20 January 2012

**Response to Submissions
s75W Modification 2
Appin Mine Surface Gas Management Project (08_0256)**

Illawarra Coal response to Submissions

Figure D-3 MSGD Site 1 Barrier Plan

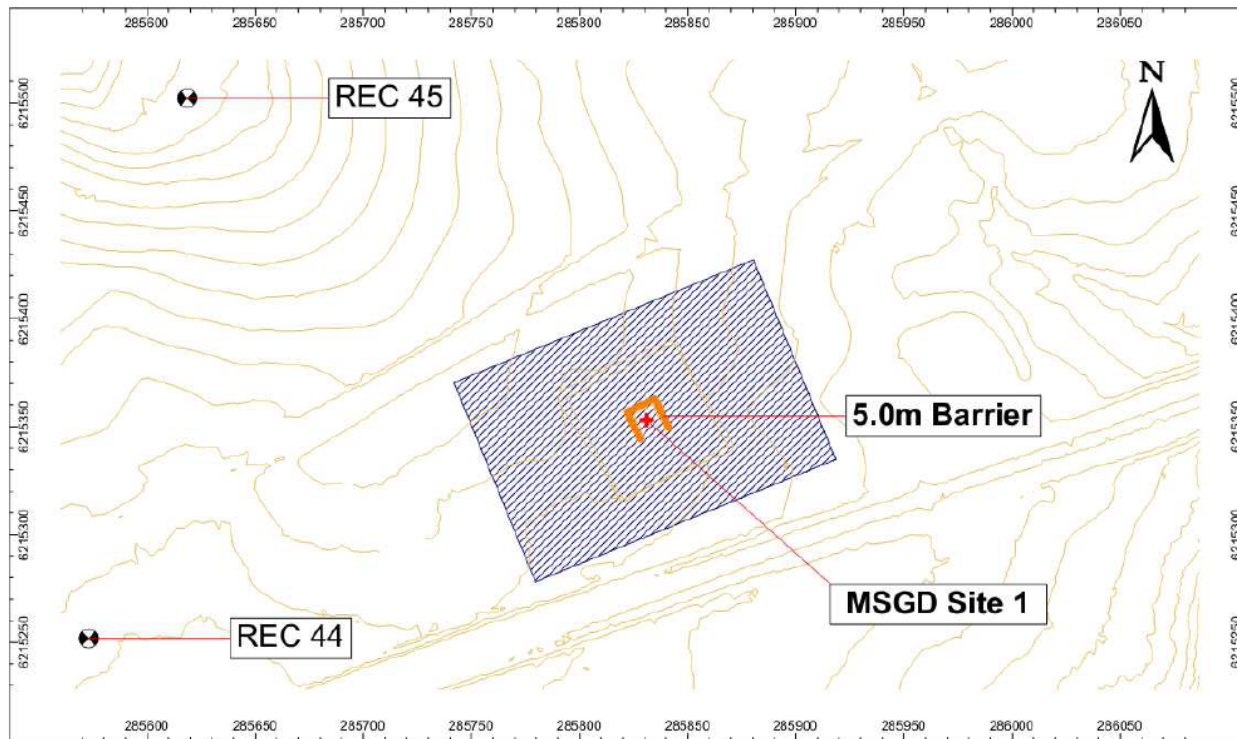
To shield the MSGD site compounds 1 and 2 during the drilling phase from public view as much as possible Illawarra Coal will install noise barriers and shade cloth around the perimeter of these compounds. These facilities would be of a colour that is sympathetic to the adjacent area, to better blend these sites into the existing rural aesthetics of the area. To minimise the visual impact of 24 hour drilling Illawarra Coal will consider the location and shielding of lights, where possible, to prevent unnecessary light spillage from night time drilling operations.

Figure 3: Proposed location of MSGD Infrastructure

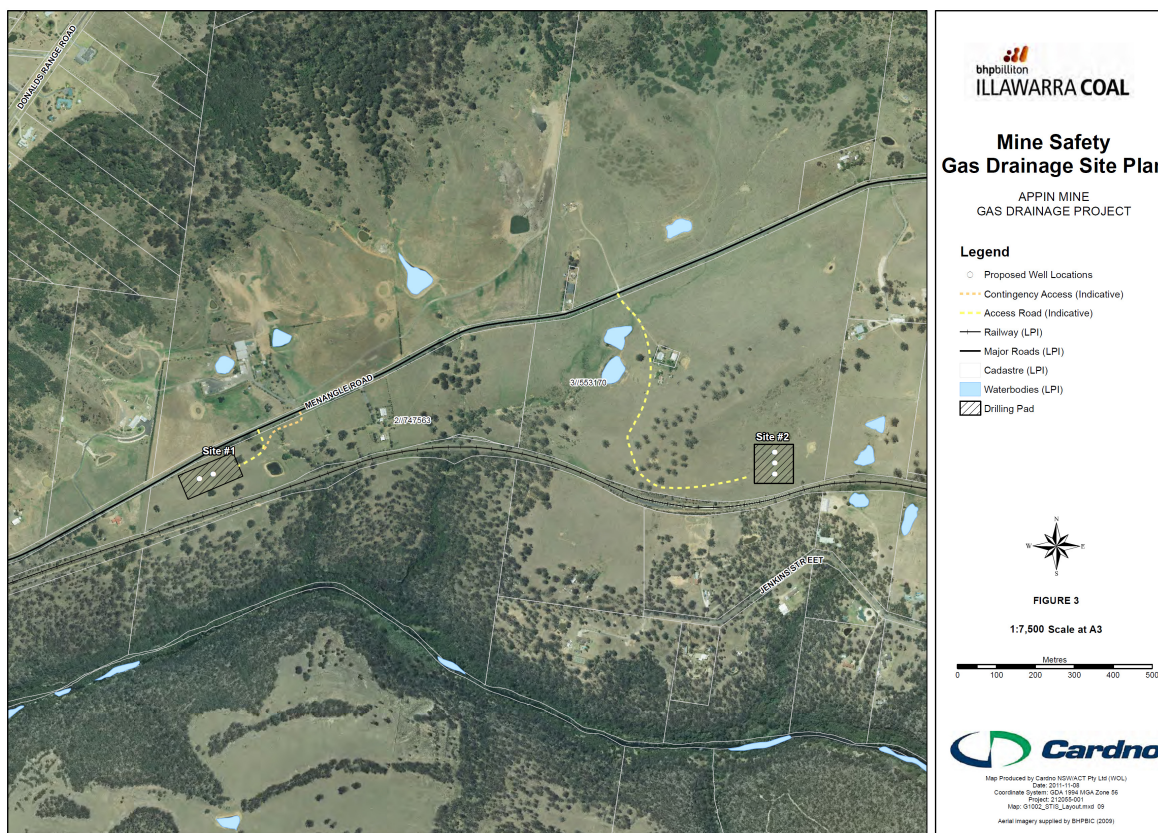
The preferred access location for MSGD Site 1 was selected because it was identified as the safest location without constructing the access road over a creek / drainage line (which would be required by the contingency access point) and was compliant with the Austroads "Guide to Road Design Part 3: Geometric Design (2010)".

It is recognised the sighting distance for Site 1 is greater for the contingency access location, however the sighting distance for the preferred access location is compliant with the Austroads "Guide to Road Design Part 3: Geometric Design (2010)". The minimum sight distance calculated

from Table 5.4 of the aforementioned standards is 193m based on a reaction time of 2.5 seconds, a negative grade of 4% and a speed limit of 100km per hour. From our site analysis (see Appendix C), the sight distance is in the vicinity of 230m from the south west direction along Menangle Road.

In summary, the proposed access location for Site 1 was selected to limit the area of disturbed land, eliminate any disturbance to a natural waterway (the creek), reduce the risk of disturbing heritage items whilst complying to the relevant Austroads Standards (note: also complies with RTA Road Design Standards (1988)).

The preferred access option is the most appropriate location for access. Notwithstanding the above, Illawarra Coal retains the option to revert to the contingency access should the preferred access be unable to meet RMS' requirements.
